Subject: GreenWay Submission from Bicycle NSW

Bicycle NSW submission

Sydney Light Rail Extension - Inner West, Dulwich Hill to
Lilyfield

Figure 6.1b Key features of the project
Note: Indicative only, subject to detail design.

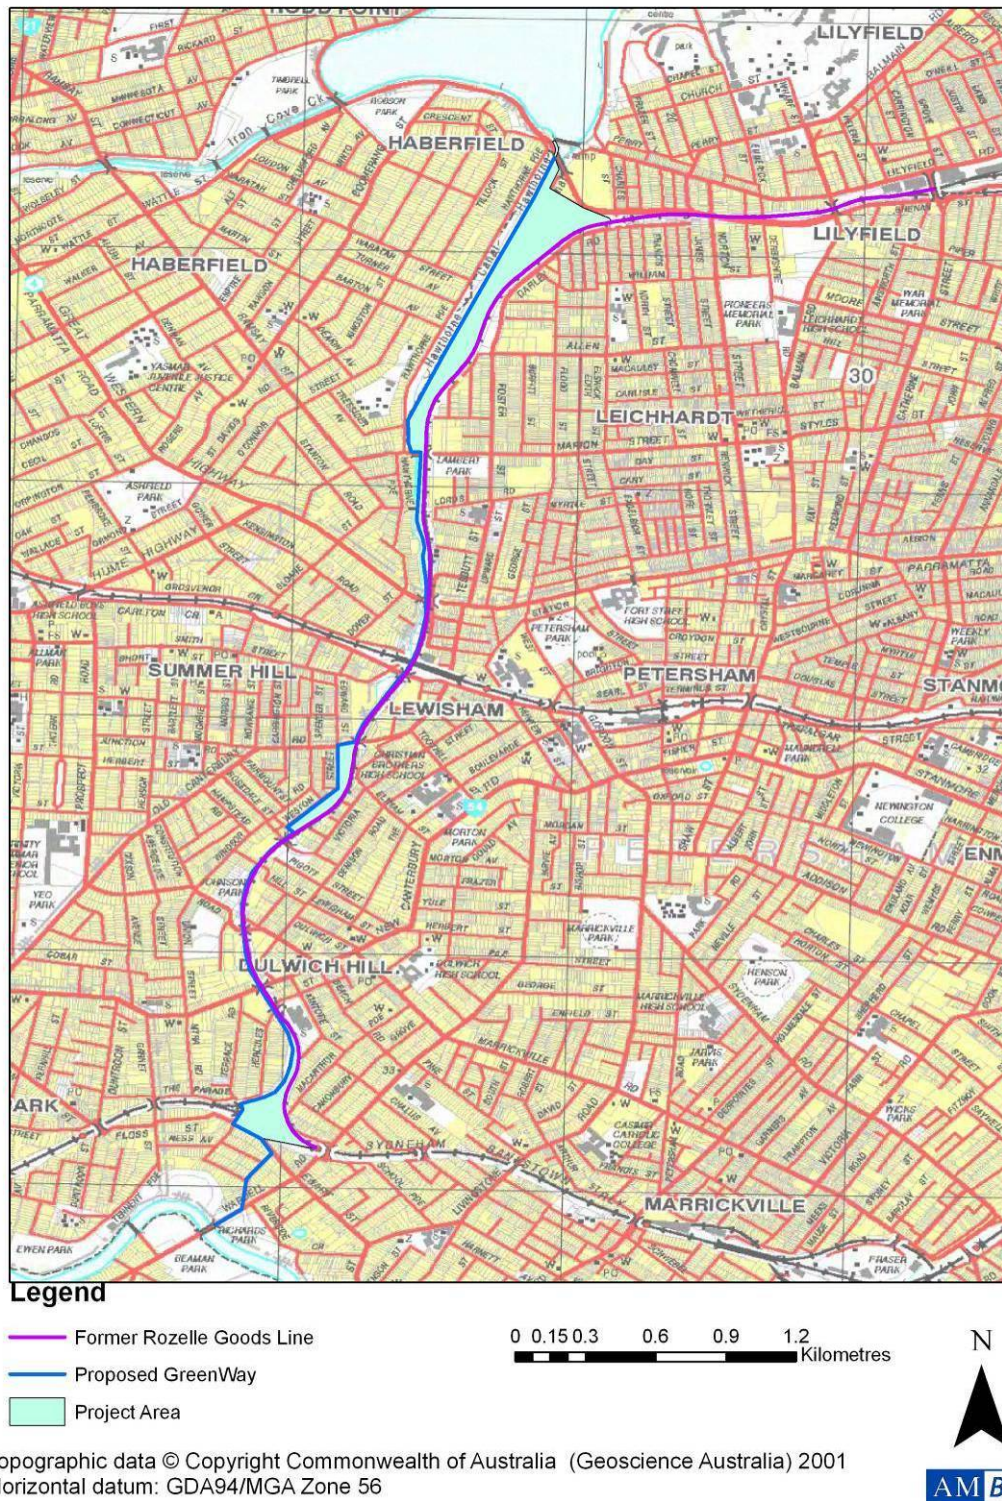
BNSW notes that the EA does not justify the alignment for the Greenway path on the western side of the Hawthorne Canal, through Richard Muirden Reserve (Fig 6.1 (c) and Fig 6.1 (b)) compared to an alignment on the western side of the rail alignment, north of the Marion Stop. As the EA Figures illustrate, shared paths are already located on the western side of the light rail alignment. Existing shared paths provide access to Iron Cove from Marion St, and these existing shared paths are located on either side of Hawthorne Canal. In our view, these facilities appear adequate for the mainly recreational bicycle and pedestrian traffic they cater for (and are likely to cater for in the future).

Figure 6.1e Key features of the project
Note: Indicative only, subject to detail design.

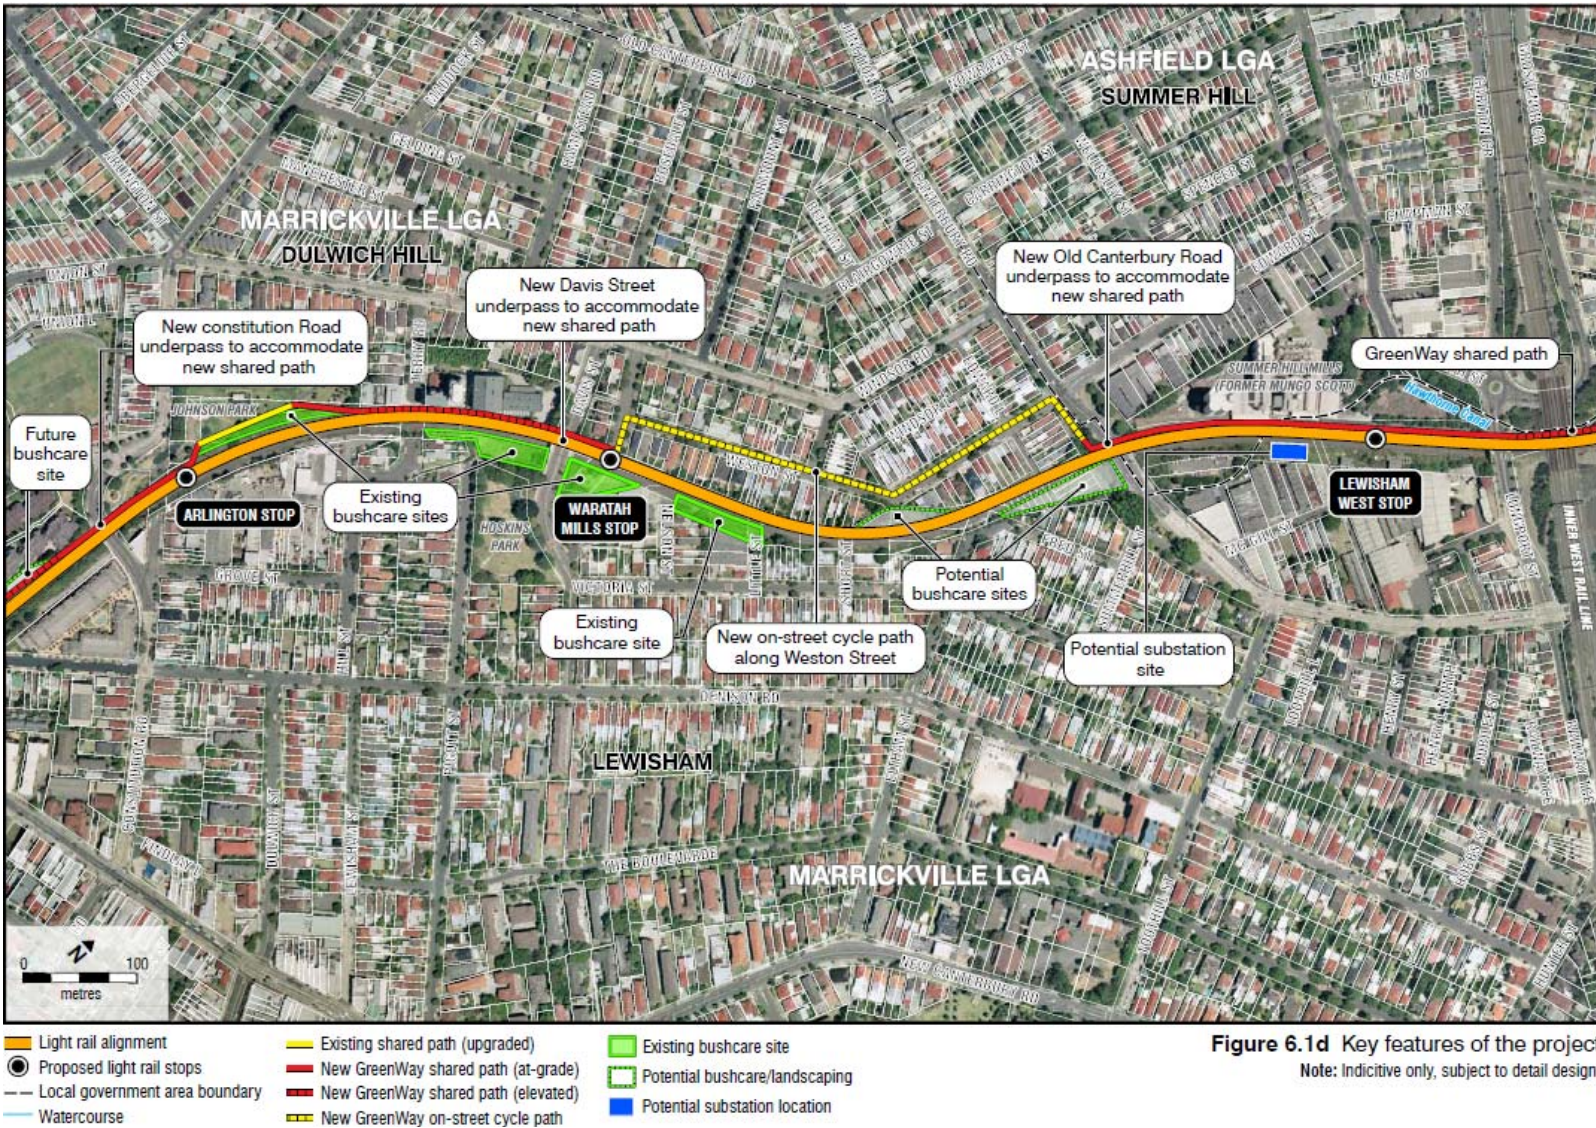
Bicycle NSW **also supports** the use of the ‘orange’ option along Weston Street (Fig 6.1 (d)), and Johnson Park (Fig 6.1 (d)) utilising existing road and path networks. At both these sites, the route for the GreenWay path is situated on the western side of the light rail alignment.
